### **Final Report - Corrections Required** **Application No. LUPL-25-0008**

**Report Date: 10/02/2025**

**Document Filename : 241010\_BLR Village C Land Use Plan.pdf**

# BANNING LEWIS RANCH - VILLAGE C

LAND USE PLAN

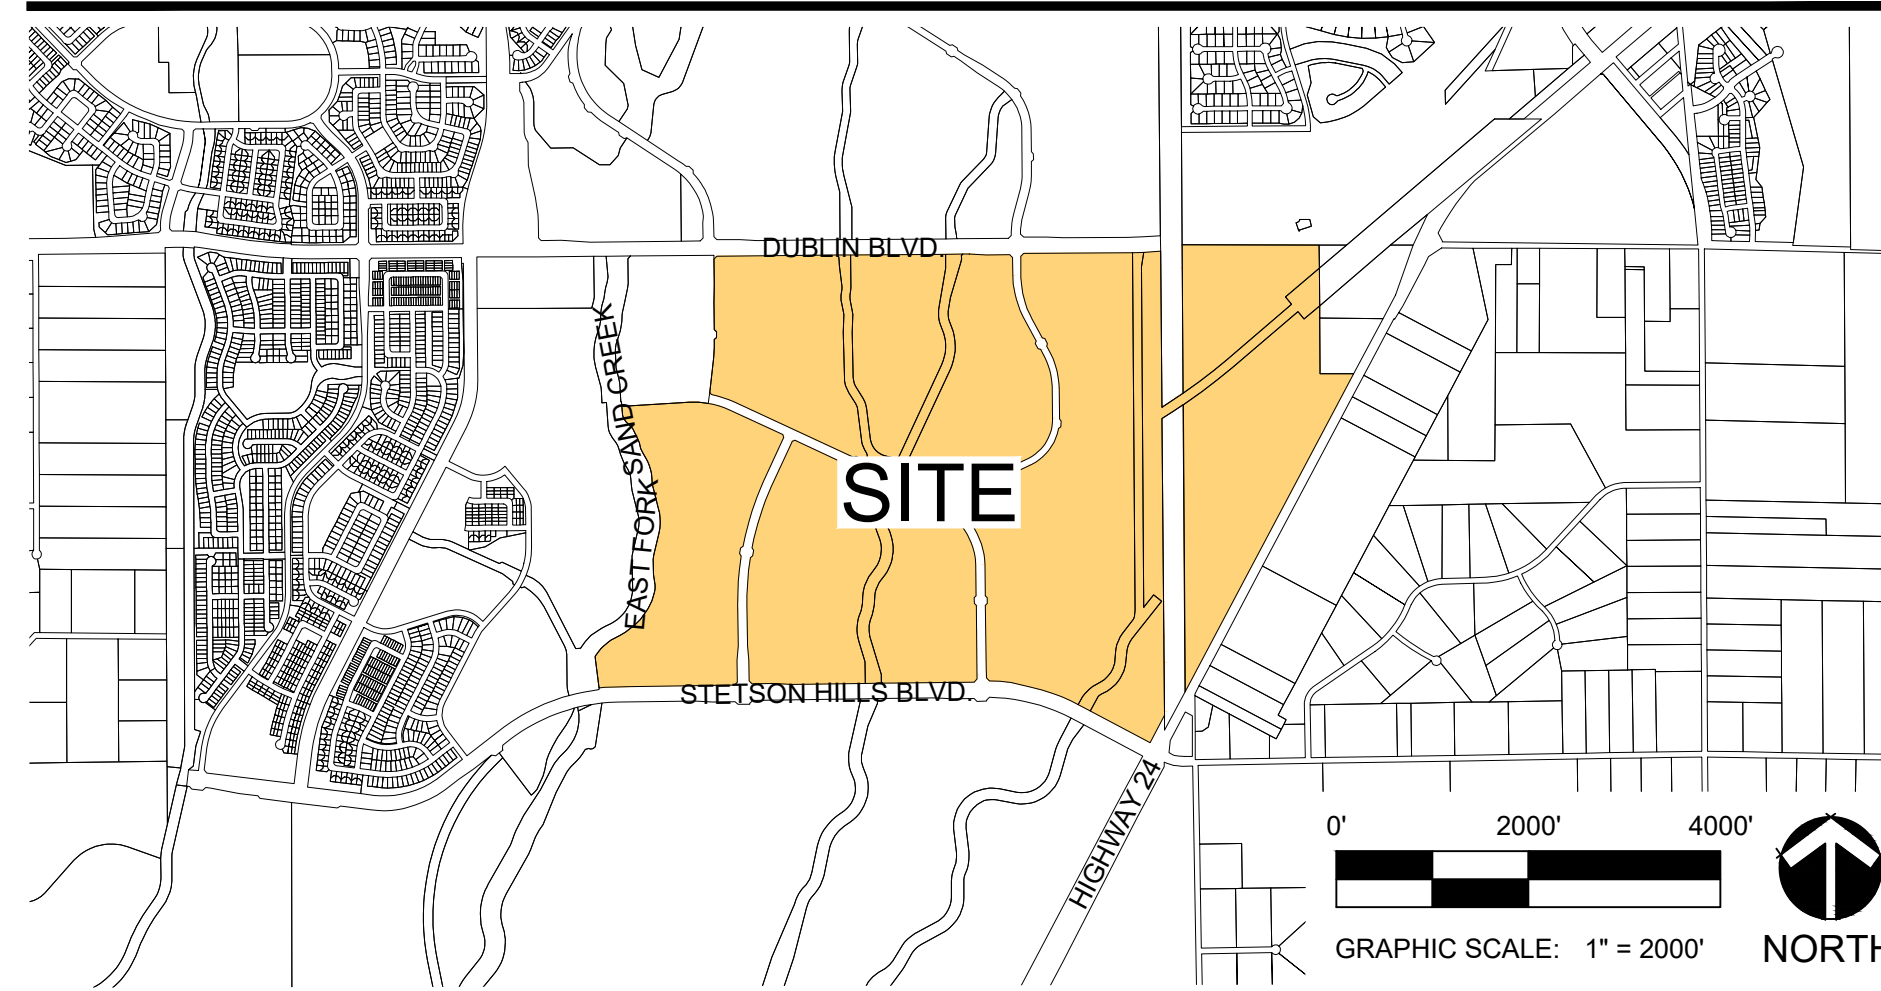
<b>Comment ID</b>	<b>Page Reference</b>	<b>Reviewer : Department</b>	<b>Review Comments</b>
74	1	Tamara Baxter : Planning	Expand GN # 26. All of the Development Standards Adjustment city files shall be identified and description of the DSA. A table format may be the best.
79	1	Tamara Baxter : Planning	Per UDC Section 7.3.201, SF detach is a conditional use in the MX-M zone district. Please note as such. Also Manufacture homes is not permitted.
80	1	Tamara Baxter : Planning	Verify these parcels. Lot 6 is proposed to be R-Flex Med.
82	1	Tamara Baxter : Planning	verify that all the acreage match those on sheet 2
84	1	Tamara Baxter : Planning	Please email affidavit for neighborhood meeting on the 16th of September
85	1	Tamara Baxter : Planning	CDOT will be added as a review with the resubmittal. Recommend that you reach out them prior to resubmittal to see if they have any comments related to Highway 24.

Per UDC Section 7.3.201, SF detach is a conditional

Verify these parcels. Lot 6 is proposed to be R-Flex

Verify that all the acreage match those on sheet 2

**BANNING LEWIS RANCH - VILLAGE C**  
 LAND USE PLAN  
 COLORADO SPRINGS, CO  
 LAND USE PLAN

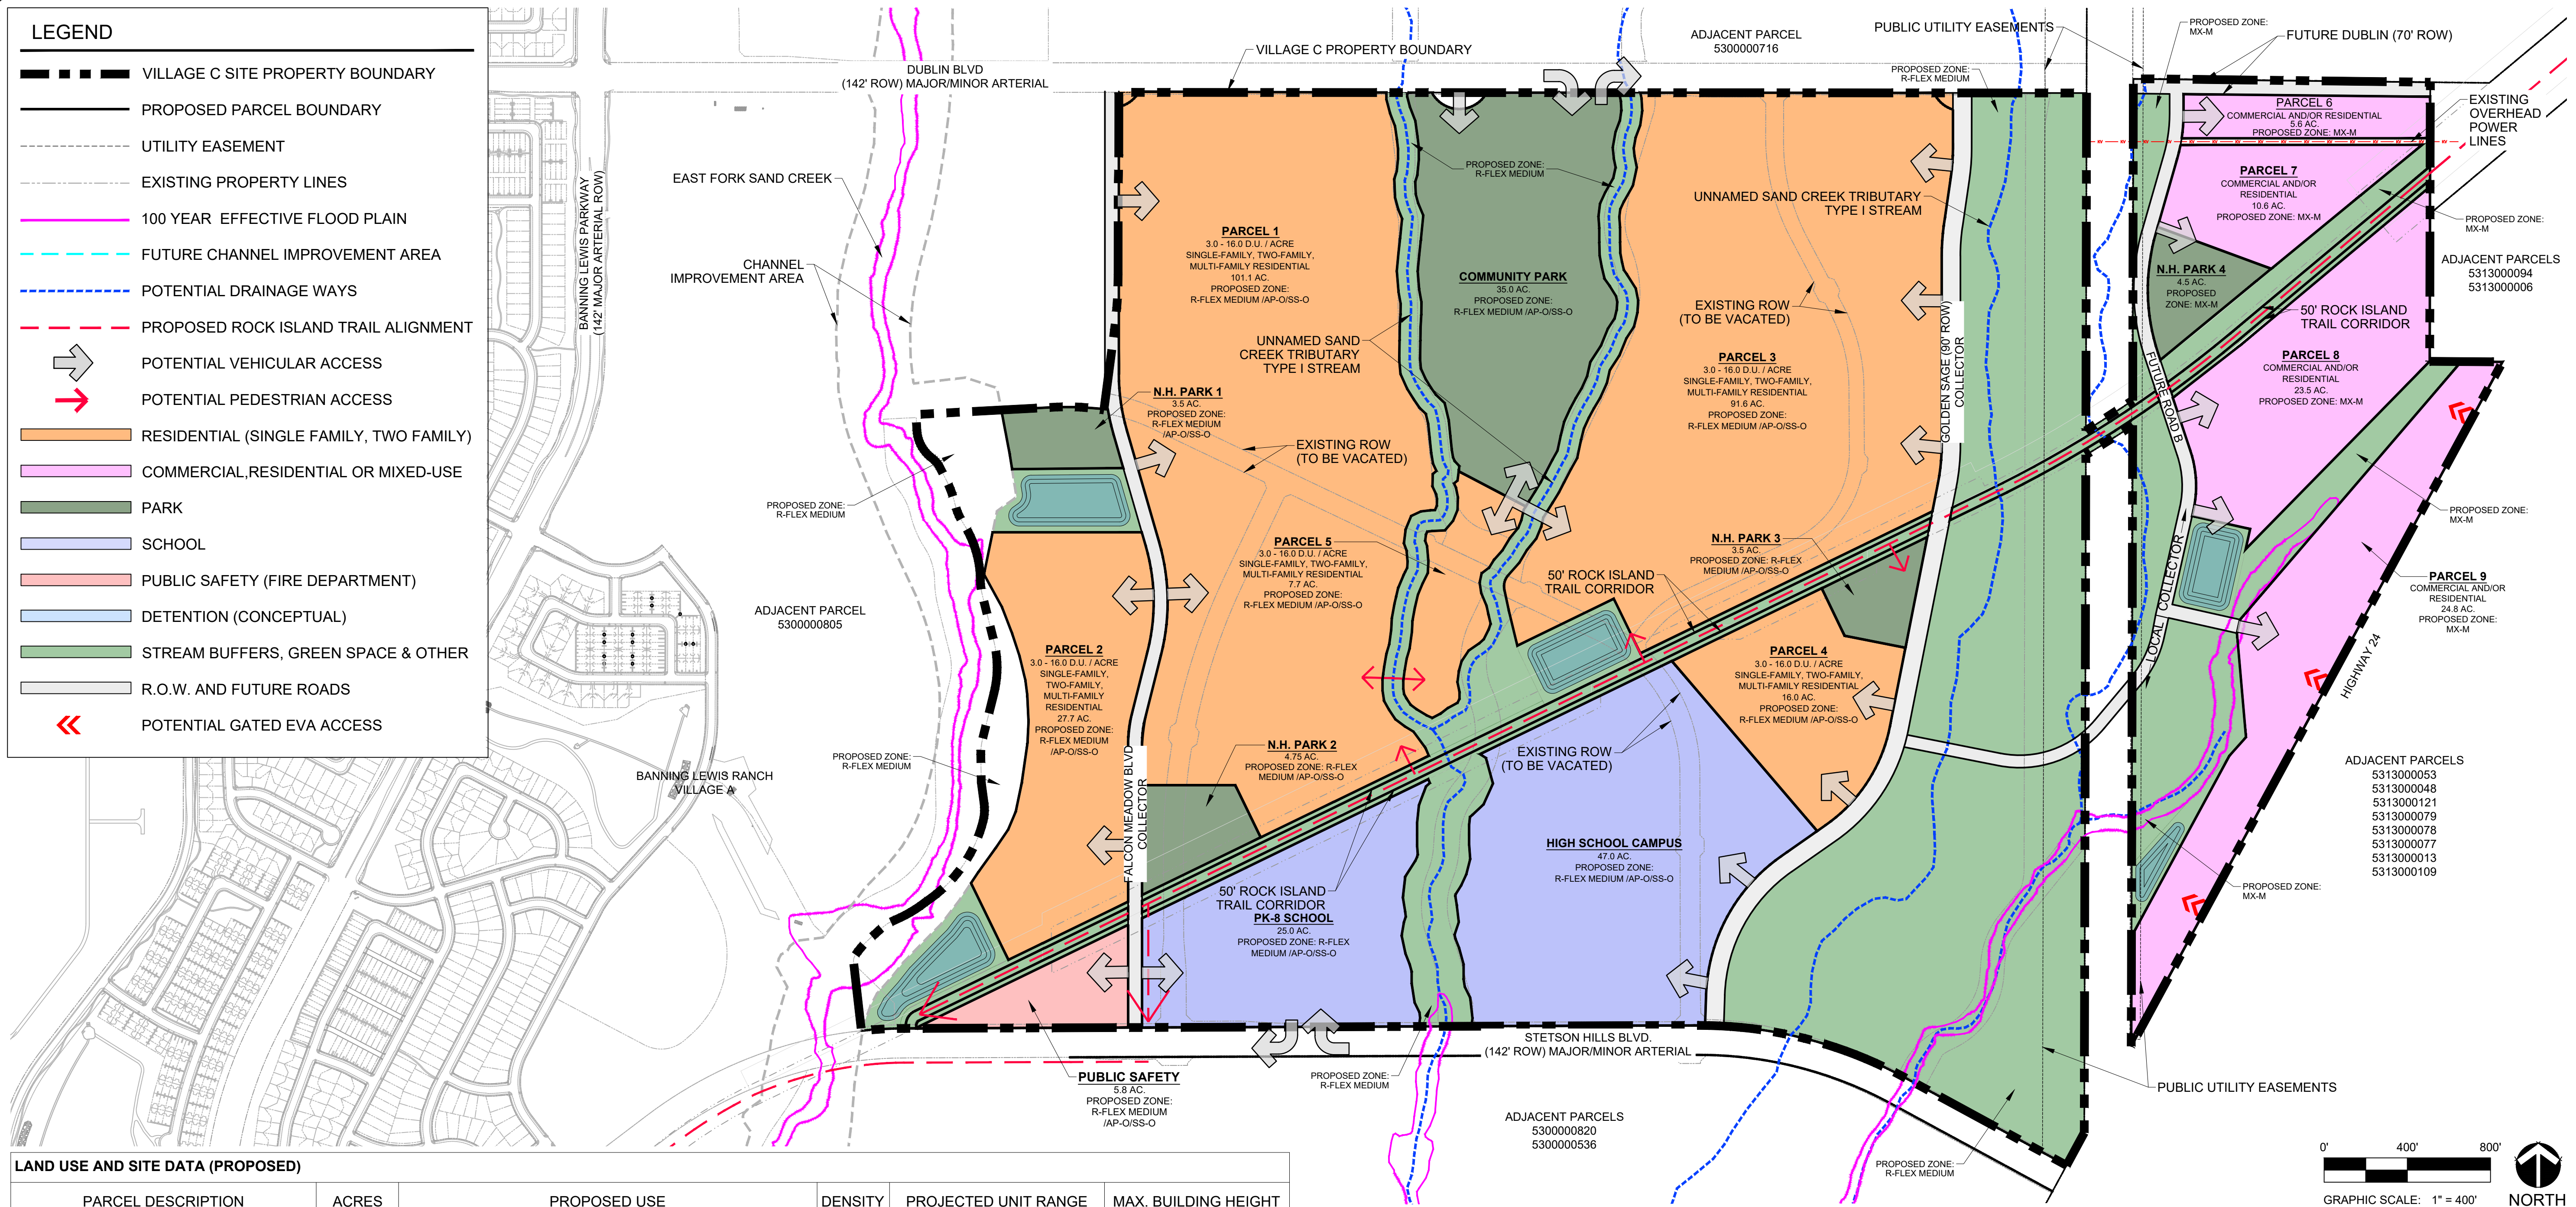
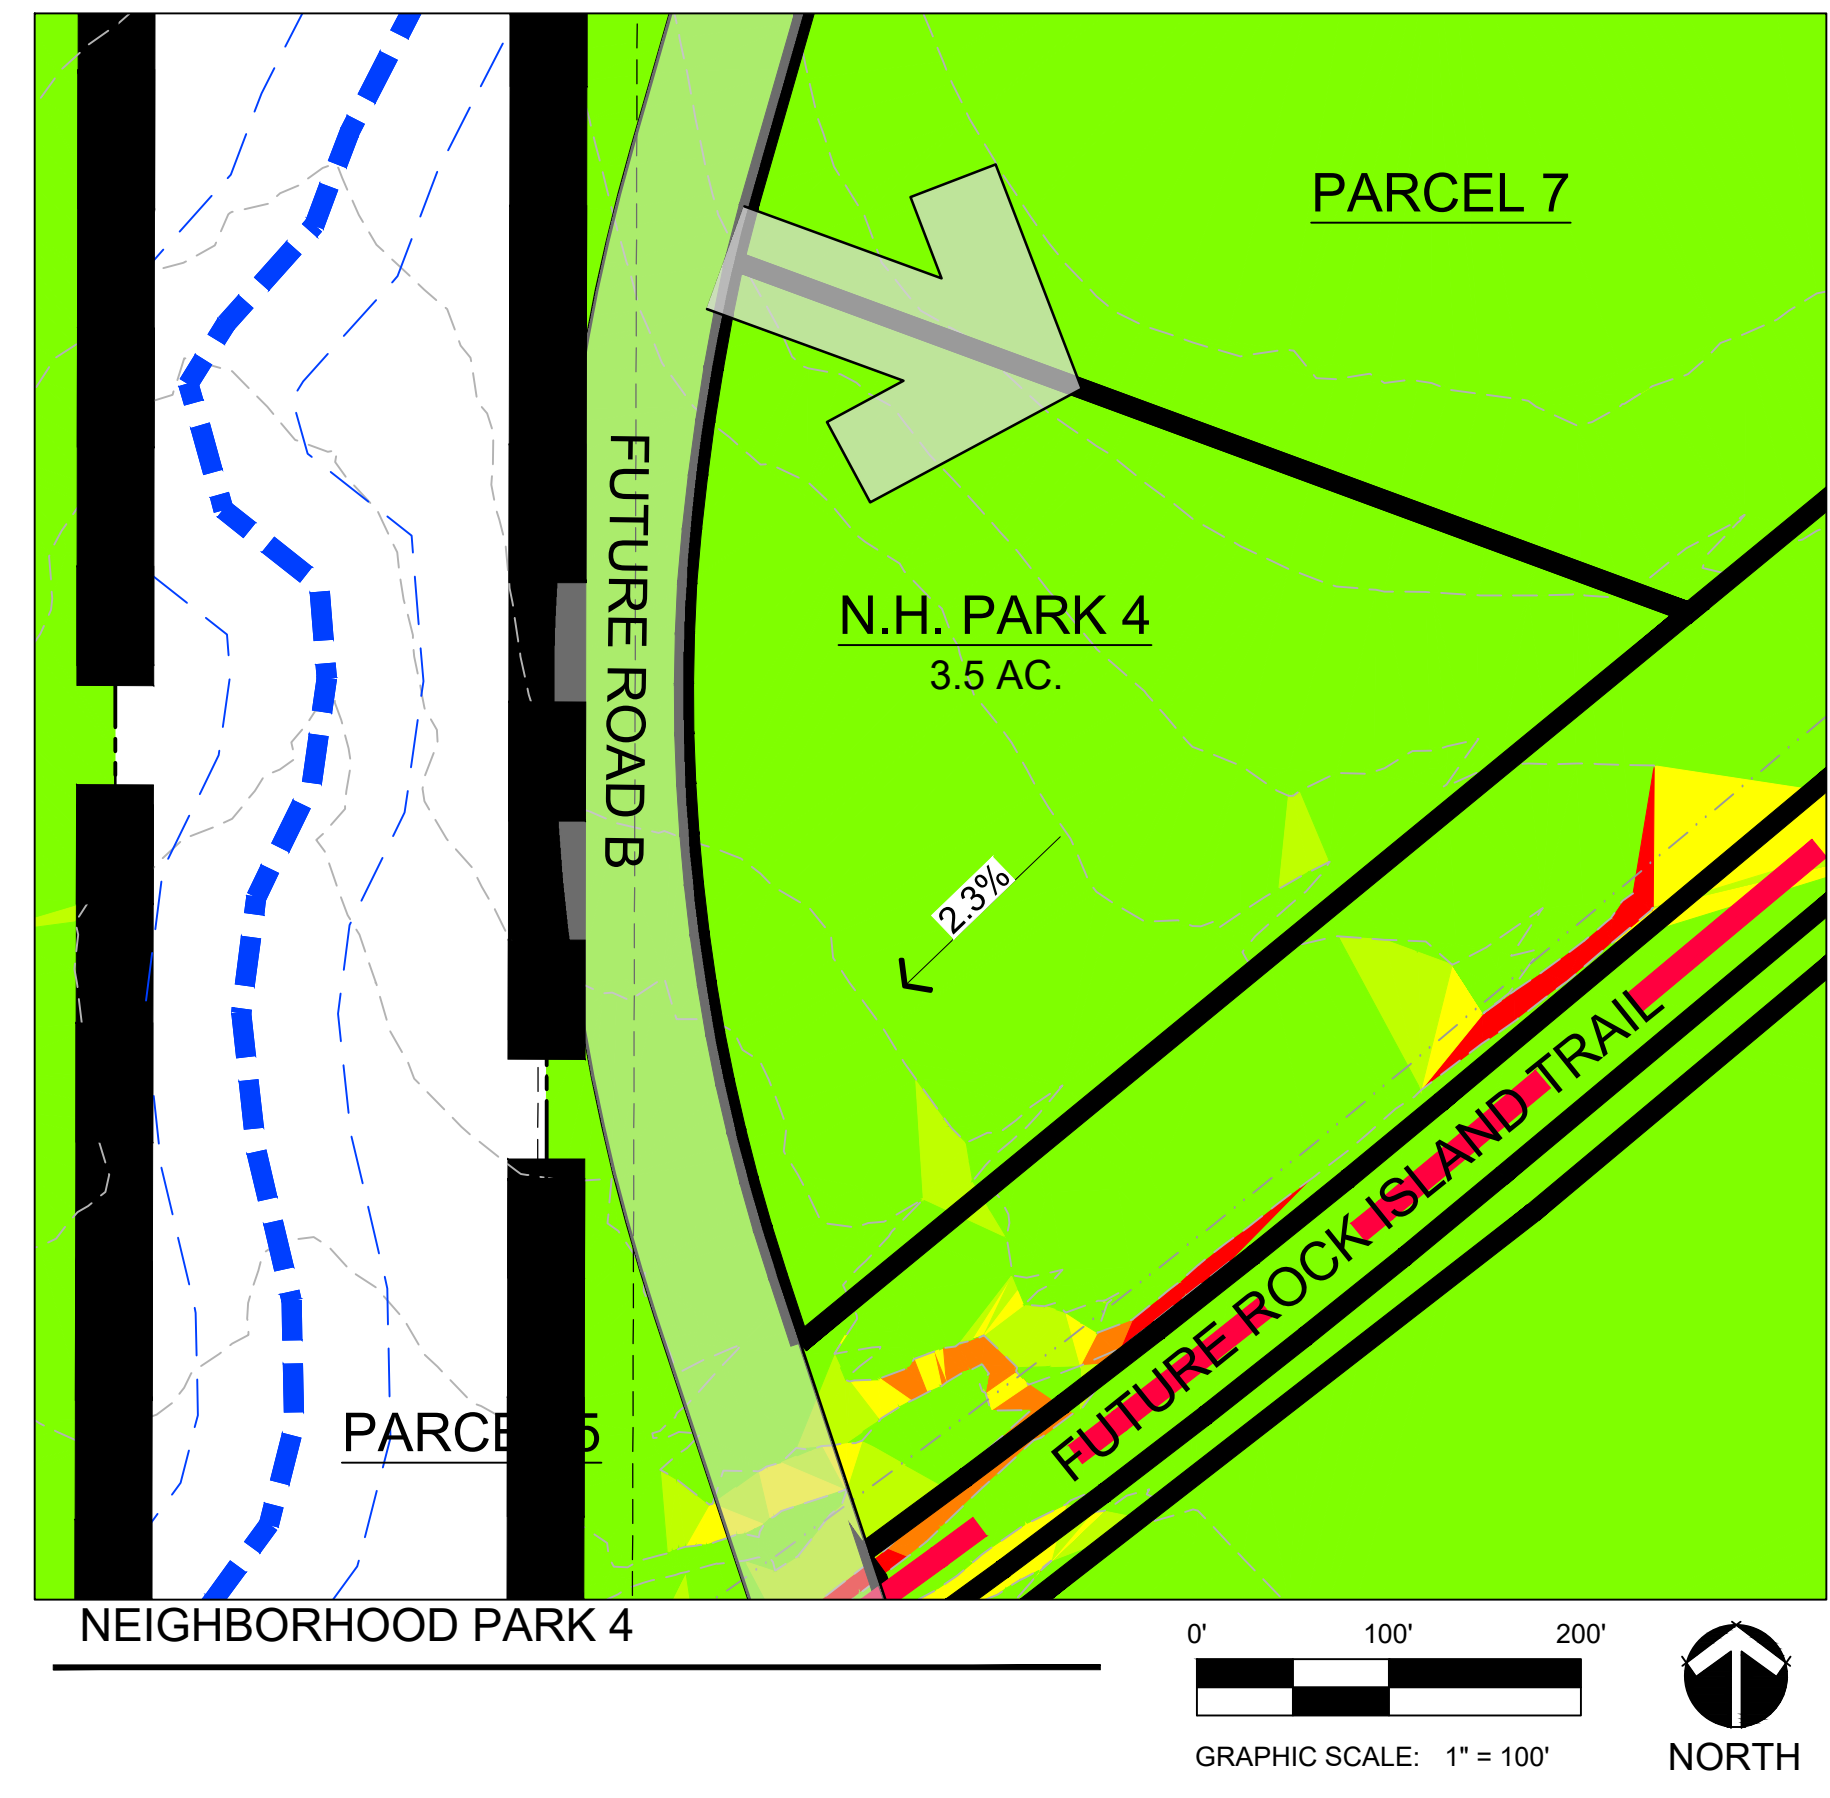
86	1	Tamara Baxter : Planning	El Paso County has not provided rereview comments. Upon receipt I will email them to you or re-run resubmittal report.
87	1	Tamara Baxter : Planning	Staff reserve the right to provide additional comments with subsequent resubmittal.
70	2	Caroline Miller : Planning	Please revise cells to match above unit counts.

<b>Comment ID</b>	<b>Page Reference</b>	<b>Reviewer : Department</b>	<b>Review Comments</b>
71	2	Caroline Miller : Planning	<p>With the change to Community Park acreage, staff would like to understand the road connections for the Community Park site and the residential area to the south. What is the thought for the road design? Will a connector road be built through the Community Park site, connecting to the residential area, thereby limiting the Community Park acreage to a full-access public road?</p> <p>In addition, will there be any other road access points off of Dublin, or just the Community Park area? Feel free to reach out to the reviewer to discuss in a meeting if preferred.</p>
72	2	Caroline Miller : Planning	Parks is awaiting feedback regarding the developer building the Community Park, then dedicating it to the city. A Community Park amenity list was provided in April 2025 to help the conceptual feasibility discussions. Notes will likely be added to this LUP in the future, upon developer response.

75	2	Tamara Baxter : Planning	What is the zoning for this area? Please call out.
76	2	Tamara Baxter : Planning	Please call out zoning for this area.
77	2	Tamara Baxter : Planning	Please call out zoning for this area. Should be reflective of the area shown in ZONE-25-0020
78	2	Tamara Baxter : Planning	Please call out zoning for this area. Should be reflective of ZONE-25-0021
81	2	Tamara Baxter : Planning	As noted on the cover sheet, SF detached are conditional use in the MX-M zone district
83	2	Tamara Baxter : Planning	Please clean up overlap so text is legible.
88	2	Tamara Baxter : Planning	Will future residential in this area be limited to the 3-156 du/ac, similar to R-Flex Med?
69	3	Caroline Miller : Planning	Please update Park Analysis to show 30 acre Community Park Site.
73	7	Caroline Miller : Planning	Please confirm that the potential wetlands will not pose a limitation to Community Park development over lot grading.
